**WELWYN HATFIELD BOROUGH COUNCIL
EXECUTIVE DIRECTOR - PLANNING, PUBLIC PROTECTION AND GOVERNANCE**

DELEGATED APPLICATION

Application No: 6/2020/1768/HOUSE
Location: 57 The Ridgeway, Cuffley, Potters Bar, EN6 4BD
Proposal: Increase ridge height to provide full first floor. Two storey side and rear extensions, with front porch canopy.
Officer: Mr David Elmore

Recommendation: Refused

P101

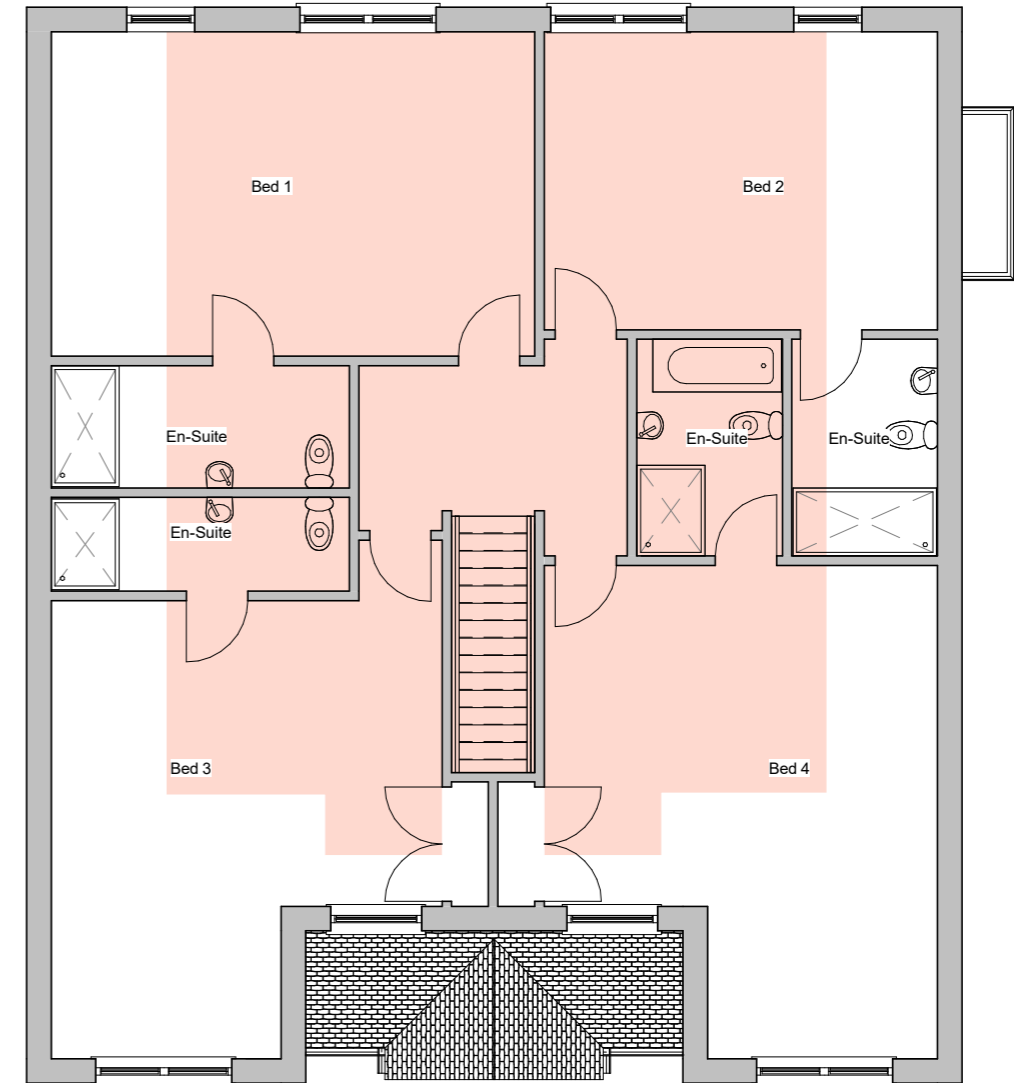
Publicity	Neighbour letters sent
Summary of neighbour responses	<p>Anonymous objection received and summarised as follows:</p> <ul style="list-style-type: none"> • Out of character with dwelling and area • Loss of light to the neighbouring sides • Overshadowing • Loss of privacy from first floor side windows
Consultees and responses	No representations received
Relevant Policies	
<input checked="" type="checkbox"/> NPPF <input checked="" type="checkbox"/> D1 <input checked="" type="checkbox"/> D2 <input checked="" type="checkbox"/> GBSP1 <input type="checkbox"/> GBSP2 <input type="checkbox"/> M14 <input checked="" type="checkbox"/> Supplementary Design Guidance <input type="checkbox"/> Supplementary Parking Guidance <input type="checkbox"/> Interim Policy for car parking and garage sizes Others: Policies RA3 and RA10 of the District Plan	
Main Issues	
Green Belt	<p>The application site lies with the Green Belt. Policy GBSP1 of the District Plan states that the Green Belt will be maintained in the Borough as defined in the Proposals Map.</p> <p><i>Appropriateness</i></p> <p>Paragraph 145 of the NPPF outlines that a local planning authority should regard the construction of new buildings as inappropriate in the Green Belt, apart from a limited number of exceptions. One of these exceptions is the extension or alteration of a building provided that it does not result in disproportionate additions over and above the size of the original building. This approach is broadly consistent with Policy RA3 of the District Plan.</p> <p>Neither the District Plan or NPPF provide any detailed guidance on how to determine whether an extension is disproportionate. This is, therefore, ultimately a planning judgement of fact and degree, which demands that each proposal is considered in relation to the size and appearance of the original building. The proposed increase in volume, footprint and floor area are commonly used indicators, however, as well as mathematical calculations, the visual impact of the extension has to be considered.</p> <p>The NPPF defines “original building” as a building as it existed in July 1948 or, if constructed after that date, as it was originally built.</p> <p>The original building was a bungalow with a footprint (and floor area) of approximately 146sqm. It had a hip roof which was stepped at the ridge giving the building a height of between 6.1-7.4 metres.</p> <p>A side and rear ‘infill’ extension and front, side and rear dormer were added. Following this, in 2007, planning permission was granted under application number S6/2007/1207/FP for a first floor rear extension and enlargements to the roof to provide a flush ridge line and additional front dormer.</p> <p>The proposed extensions and alterations would transform the current ‘chalet-style’ dwelling into a two storey property with crown roof. The resultant dwelling would have a footprint of approximately 164sqm (12.3% increase over original, floor area of approximately 328sqm (124.6% increase over original) and height of 7.2 metres.</p> <p>The increase in floor area above original would be significant and, in visual</p>

<p>term, the resultant dwelling would be considerably greater in scale and bulk than the original building.</p> <p>Having regard to the above, it is considered that the proposed extensions would result in disproportionate additions over and above the size of the original building. The proposal would therefore represent inappropriate development in the Green Belt.</p> <p><i>Openness</i></p> <p>The subject dwelling forms part of a ribbon of detached dwellings on the southern side of The Ridgeway with open countryside to the rear. The proposal would increase the height of the flank walls from single to two storey and create a large crown roof. Such additions would reduce the gaps between the dwelling and the neighbouring buildings and significantly increase the presence of the dwelling in the street scene. This would result in a reduction in the visual permeability and openness of this Green Belt location, closing down glimpsed views of the countryside beyond.</p>

P102

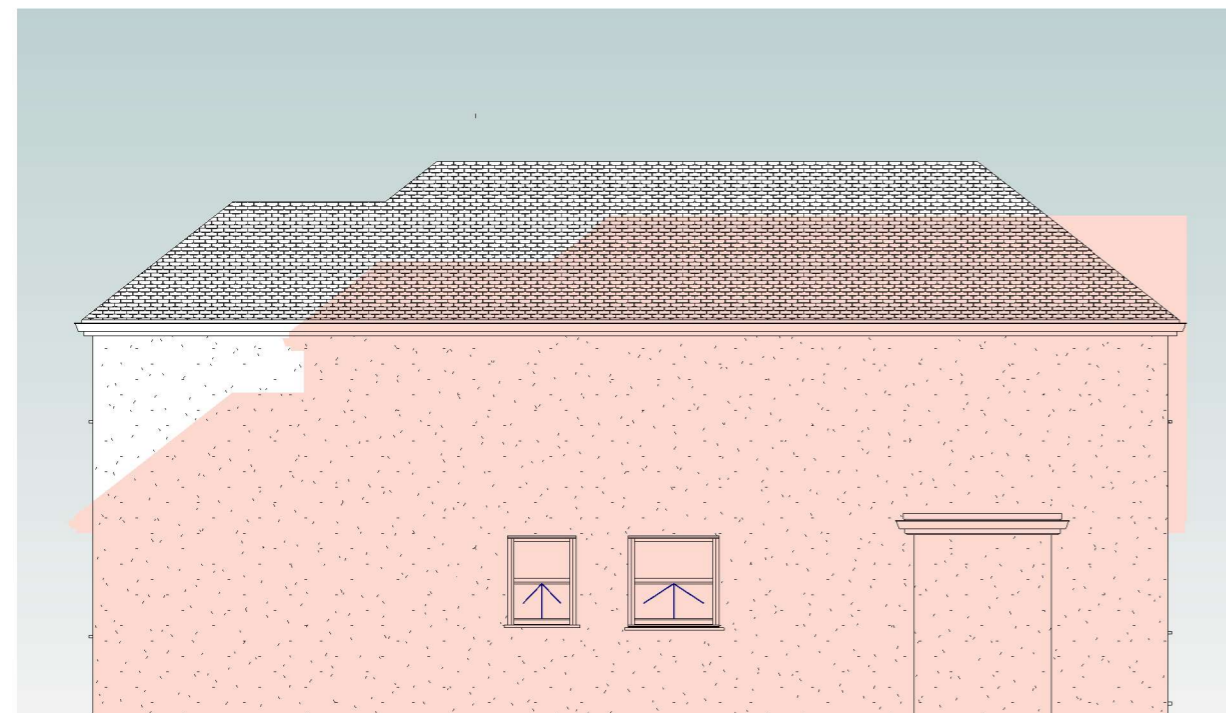
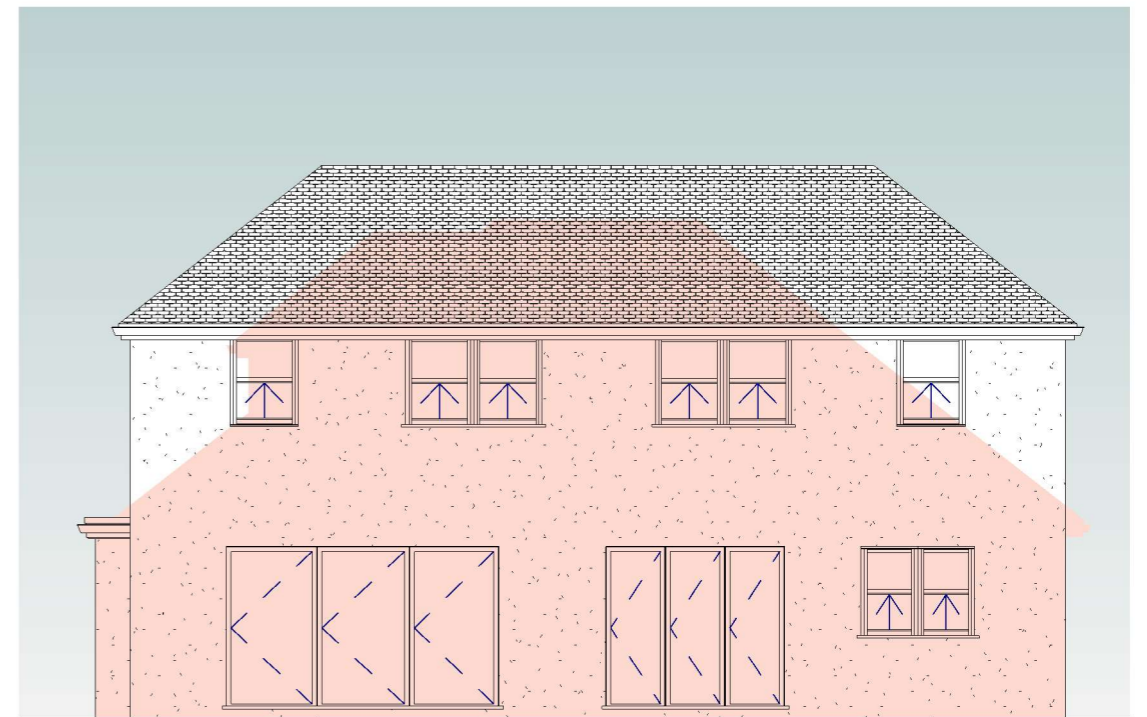
<p>Design (form, size, scale, siting) and Character (appearance within the streetscene)</p>	<p>Policies D1 and D2 of the District Plan respectively require high quality design in all new development and for proposals to respect and relate to the character and context of their location, maintaining and where possible enhancing the character of the existing area.</p> <p>The NPPF advocates high quality design and that permission should be refused for development of poor design which fails to take the opportunities available for improving the character and quality of an area the way it functions, taking into account any local design standards or style guides in plans or supplementary planning documents.</p> <p>The Council's Supplementary Design Guidance 2005 (SDG) expands on Policies D1 and D2 of the District Plan and outlines, amongst other things, that:</p> <ul style="list-style-type: none"> • Extensions should be designed to complement and reflect the design and character of the dwelling and be subordinate in scale; • The spacing of buildings adjacent to and in the immediate locality of the site should be reflected; and • For all two-storey side extensions, a minimum distance of 1 metre between the extension and the adjoining flank boundary must be maintained. This spacing is to prevent overdevelopment across plot widths and a terracing effect within areas of detached and semi-detached properties <p>This part of The Ridgeway contains a mixture of broadly chalet-style and two storey dwellings. Whilst the resultant two storey dwelling would be in keeping with the area's built context and a minimum distance of 1 metre between the extension and the adjoining flank boundary would be maintained, its size, design and appearance would contrast greatly with that of the existing dwelling. The proposal would therefore fail to complement and reflect the design and character of the dwelling or be subordinate in scale in conflict with Policy D1 of the District Plan, SDG and NPPF.</p>

<p>Impact on neighbours</p>	<p>The proposed extensions would not be unduly dominant or result in any adverse loss of daylight or sunlight to neighbouring properties considering their height, length of projection and proximity to common boundaries.</p> <p>The upper floor side walls would be void of window openings. As such, there would be no loss of privacy toward the flank windows of the next door</p>
